Thank you for the opportunity to comment on the Valley Run Short Plat, SP-07-160. Pursuant to the Memorandum of Agreement between Kittitas County and the Washington State Department of Ecology all the future residential well connections serving the proposed lots shall be required to have meters installed. Metering results shall be recorded in a manner consistent with Kittitas County and Washington State Department of Ecology requirements.

SUBJECT: Valley Run Short Plat P-07-160

VALLEY RUN SHORT PLAT
PART OF SECTION 36, T. 18 N., R. 17 E., W.M.
KITTITAS COUNTY, WASHINGTON

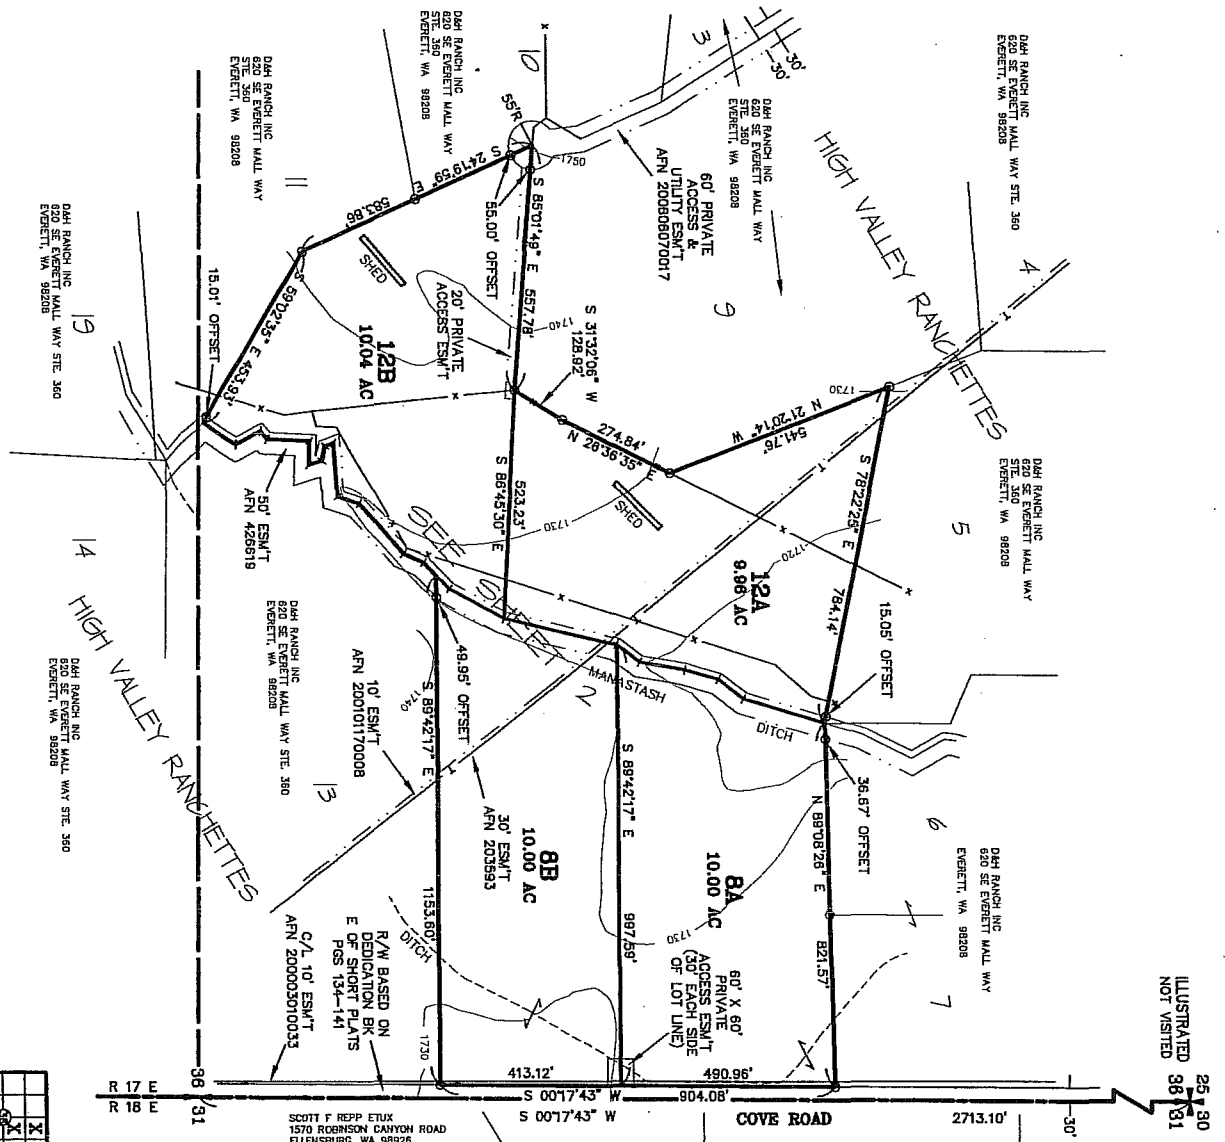
The potable water plat note is incorrect (plat note #8). Please replace the plat note with the following:

Please also include the following plat note:

2. Private Road Improvements to Access Lots 12A and 12B: Access from Robinson Canyon Road to the cul-de-sac shall be constructed to meet or exceed the conditions of a Low-Density Private Road. See Kittitas County Road Standards, 9/6/05 edition.

4. Access to Lots 8A and 8B: A joint-use driveway shall be used to access Lots 8A and 8B from Cove Road.

"The approval of this division of land includes no guarantee that there is a legal right to withdraw groundwater within the land division. The approval of this division of land provides no guarantee that use of water under the ground water exemption (RCW 90.44.050) for this plat or any portion thereof will not be subject to curtailment by the Department of Ecology or a court of law. "

"Metering will be required on all residential well connections and metering results shall be recorded in a manner consistent with Kittitas County and Washington State Department of Ecology requirements."

- a. Access easements shall be a minimum of 60' wide. The roadway shall have a minimum width of 20', with 1' shoulders, for a total width of 22'.
 - b. Minimum centerline radius will be 60'.

- c. The surface requirement is for a minimum gravel surface depth of 6".
 - d. Maximum grade is 12%.
 - e. Stopping site distance, reference AASHTO.
 - f. Entering site distance, reference AASHTO.

- a. Access easements shall be a minimum of 20' wide. The roadway width shall have a minimum width of 12'.
- b. The surface requirement is for a minimum gravel surface depth of 6".
- c. Maintenance of driveway approaches shall be the responsibility of the owner whose property they serve. The County will not maintain accesses.
- d. Any further subdivision or lots to be served by proposed access may result in further access requirements.
